COLORADO
Department of Transportation

April 23, 2024

RE: Southern Colorado Dual-Service Rail Park - SKP234

**PHASING PLAN**

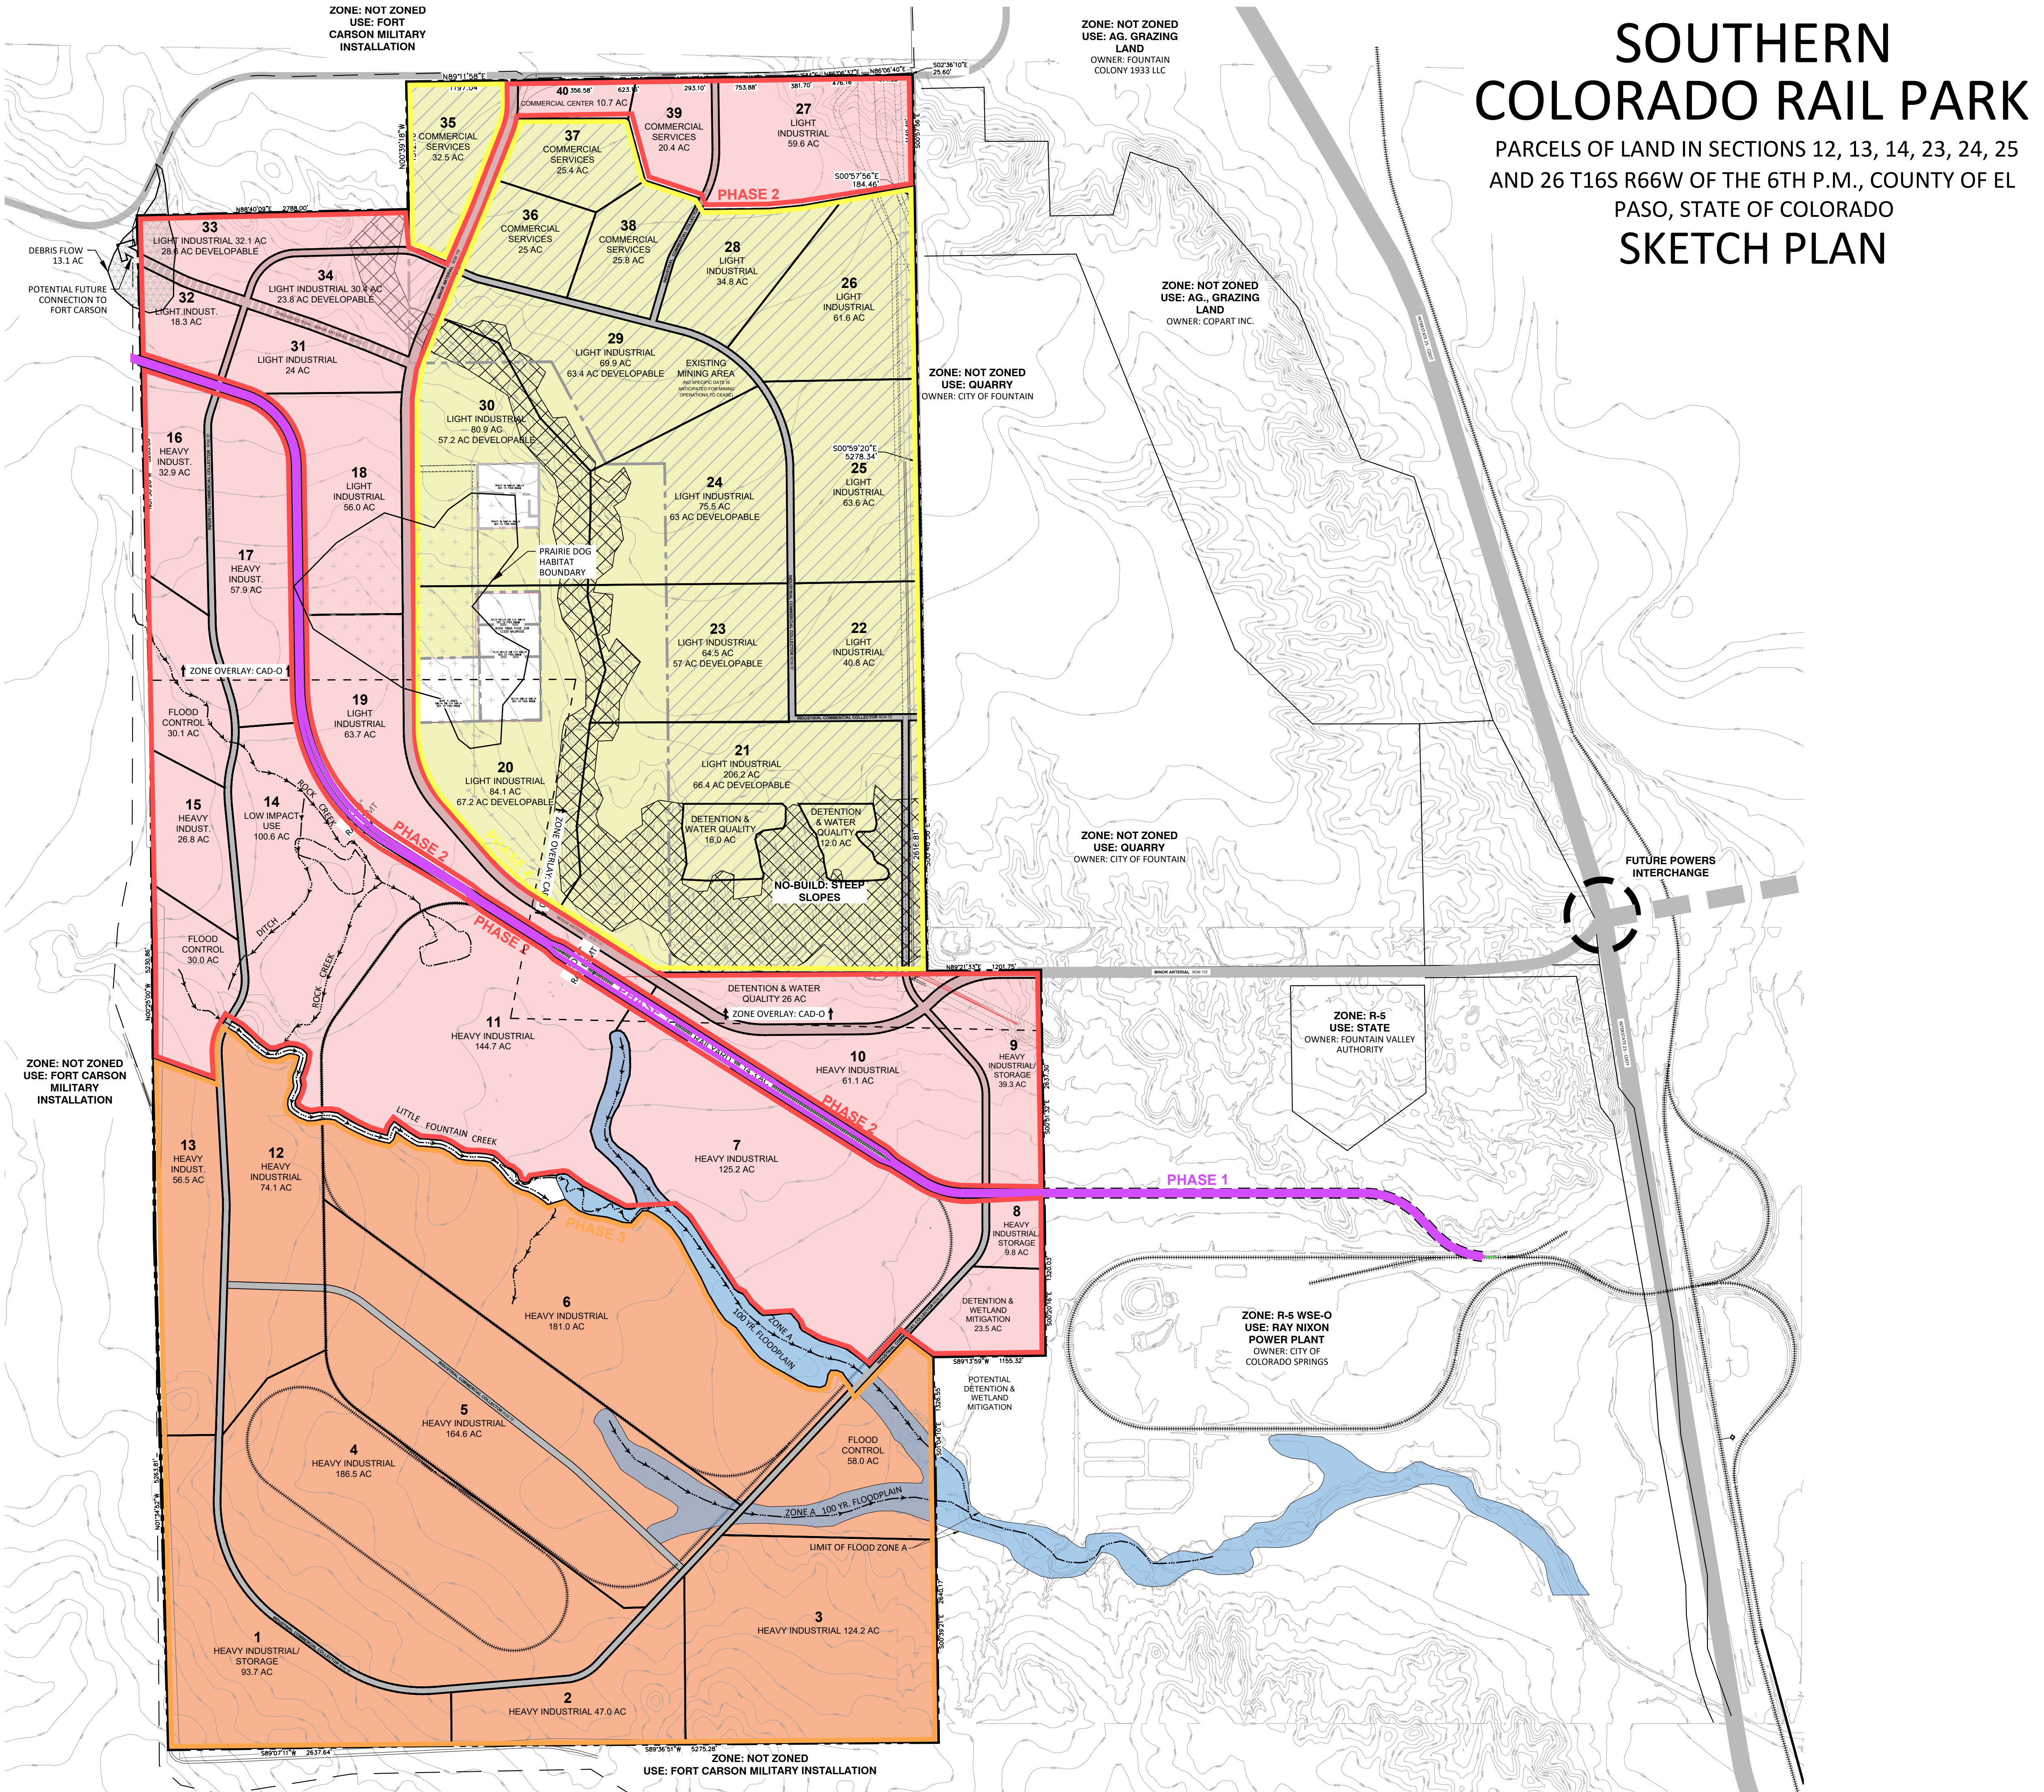
- Please provide a new study before doing the Phase 3 (start of build planned for 2035).
- We really cannot estimate any better before having more information on the I-25 and Powers Blvd potential connection.
- Escrow calculation is also premature because of this.
- The only question is if they will submit another TIS prior to 2035? The easiest option is to approve only Phases 1 and 2, so they have to apply before starting the third phase.

- *However, before the start of Phase 3 (2035), the following will be required:*
- *TIS considering Phases 3 and 4, including evaluation of interchange construction and mitigations at Exit 128 (I-25 & US85).*
